**Consultation Response from KC,
Highways Development Management****2023/91441 31, Chapel Hill, Linthwaite, Huddersfield, HD7 5NJ****Change of use and alterations to former church (B8-storage) to 9 residential units (C3) and formation of car park (Listed Building within a Conservation Area)****Date Responded:31/08/2023****Responding Officer:Ryan Kinder****Responding Ref:K2-1/31**

Planning application for Change of use and alterations to former church (B8-storage) to 9 residential units (C3) and formation of car park (Listed Building within a Conservation Area).

**Drawing:**  
 Proposed  
 Site Plan

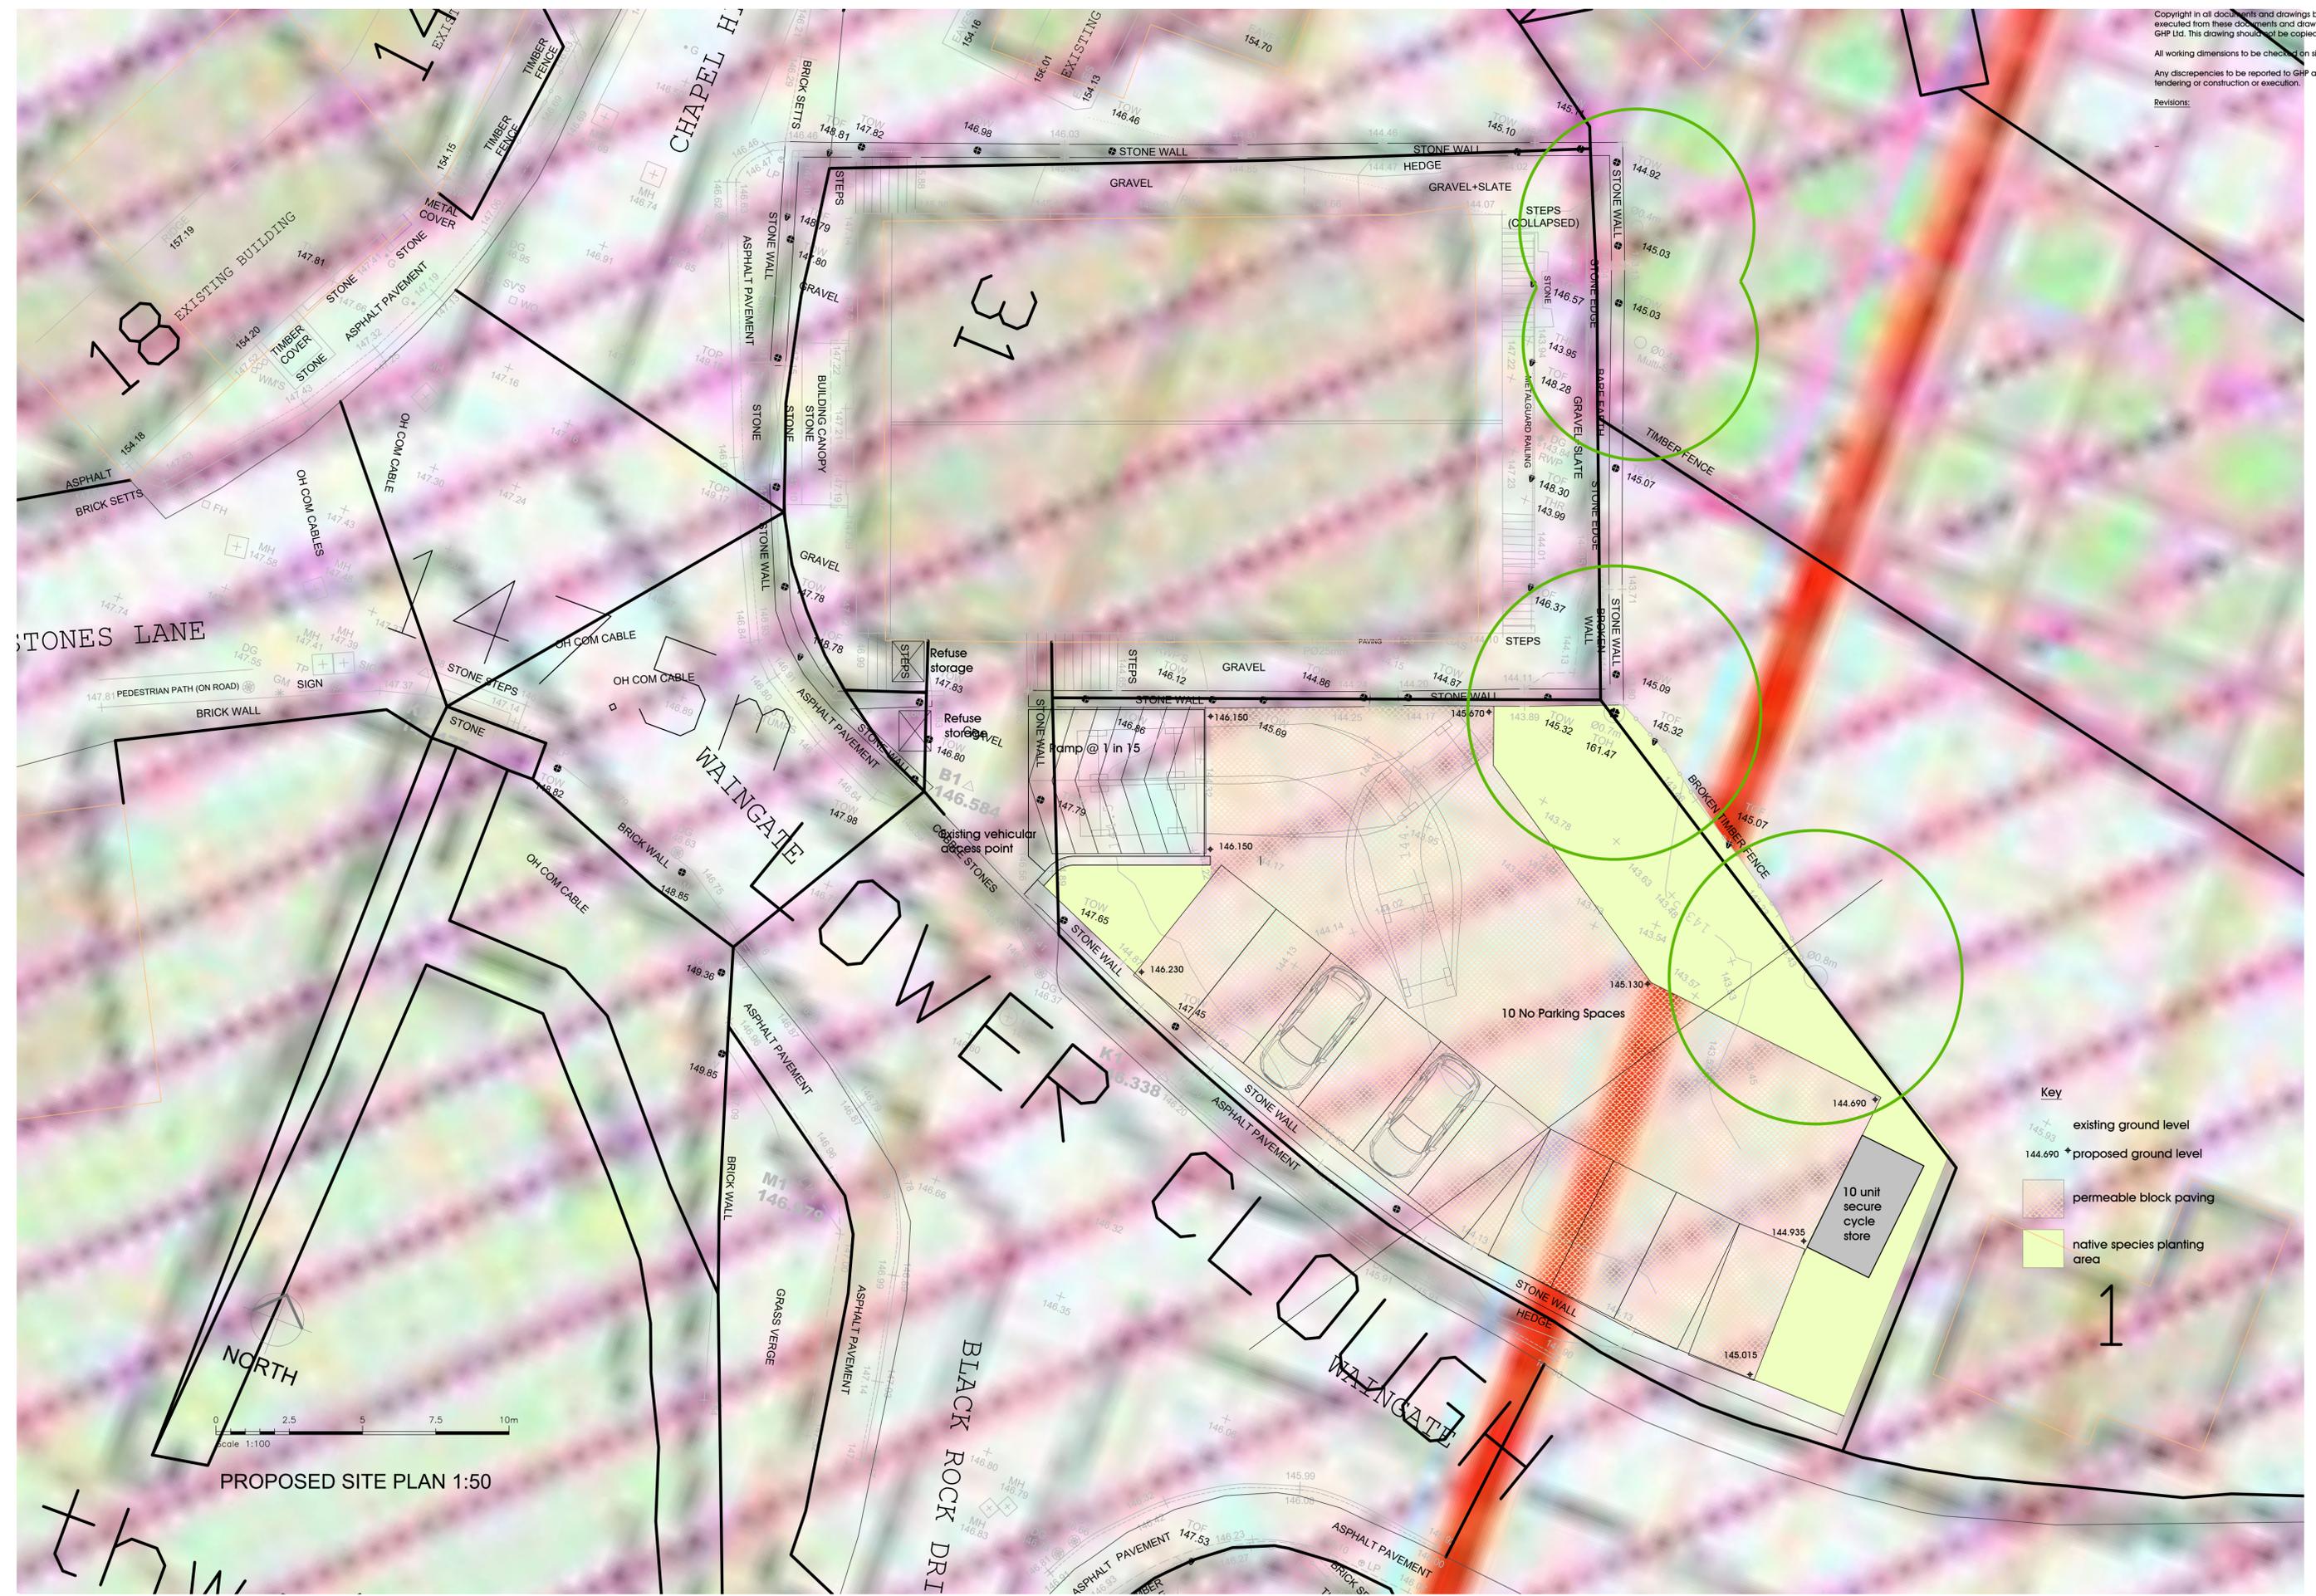
Access to the proposed site is via an existing access onto Waingate, it appears this is to be widened to accommodate two way vehicular movements to and from the site. In terms of visibility the existing wall to the site frontage is less than 1.0m in height which provides adequate visibility given its proximity to the junction with Chapel Hill, driven speeds are considered to be low at this location. To ensure this is maintained a suitable condition will be suggested accordingly.

There is an indicative number of 10 spaces proposed, of which it is assumed one is for visitor parking, whilst there is a shortfall of one visitor space, HDM would accept the overall parking provision on this occasion.

The provision for storage of waste has been indicated on the submitted plans, a more comprehensive response has been provided regarding this from the Council's Strategic Waste team, they have requested further information regarding the location of the storage area. With regards to access for refuse collection vehicles it is acknowledged that refuse collection vehicles will not be able to enter the site so any collection will be kerb side via Waingate.

With the exception of further information requested from Strategic Waste, the overall proposal is considered acceptable from a highways perspective. Please include the following highways conditions:

Areas to be surfaced and drained

The buildings shall not be occupied until the areas to be used by vehicles and/or pedestrians have been surfaced and drained in accordance with details that have previously been approved in writing by the Local Planning Authority.

Nothing to be ... within 2m

Nothing shall be permitted to be planted or erected within a strip of land 2.0m deep measured from the carriageway edge of Waingate along the full frontage of the site which exceeds 1.0m in height above the level of the adjoining highway.
